Your Ref: 2021/91871

Our Ref: X008895

3rd June 2021

Land adj. High Street and Challenge Way, Hanging Heaton, Batley - Erection of residential development (55 dwellings) including access and associated infrastructure

Figure 3 – Surface water flow path to northern watercourses

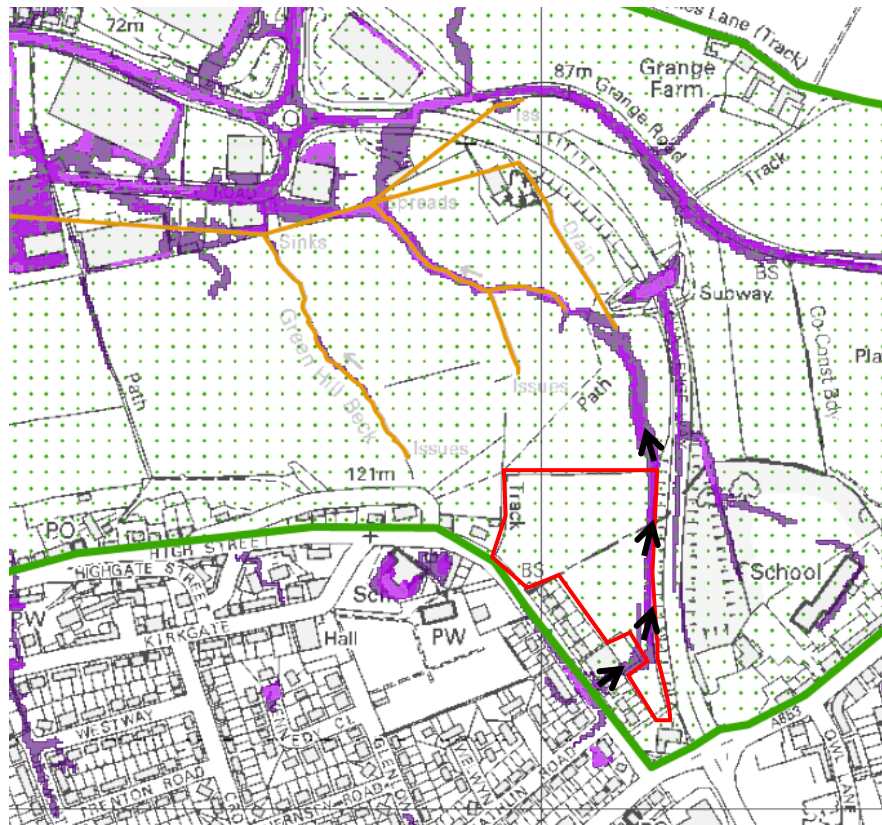
1) The submitted Flood Risk Assessment prepared by Eastwood and Partners (Report dated 21/04/21) is generally acceptable, but further information is required to determine a suitable outfall for the site's surface water. If planning permission is granted, the matter can be controlled via condition. In summary, the report states that:

- a) foul water will discharge to the public combined sewer network;
- b) sub-soil conditions do not support the use of soakaways;
- c) a watercourse exists near to the site – connection subject to Environment Agency / Local Land Drainage Authority / Internal Drainage Board requirements – the viability of these watercourses has yet to be confirmed; and
- d) as a last resort, surface water will discharge to the public surface water network at a restricted rate of no more than 3.5 litres per second if a discharge to watercourse is discounted.

Yorkshire Water promote the surface water disposal hierarchy and the developer must provide evidence to demonstrate that surface water disposal via watercourse is not reasonably practical before considering disposal to public sewer. The developer and LPA are strongly advised to seek comments on surface water disposal from other drainage bodies as further restrictions may be imposed.

As the proposal site is currently undeveloped, no positive surface water is known to have previously discharged to the public sewer network. Surface water discharge to the existing public sewer network must only be as a last resort and the developer is required to eliminate other means of surface water disposal. As a last resort, and upon receipt of satisfactory evidence to confirm the reasons for rejection of other methods of surface water disposal, curtilage surface water may discharge to public surface water network at a restricted rate of no more than 3.5 litres per second.
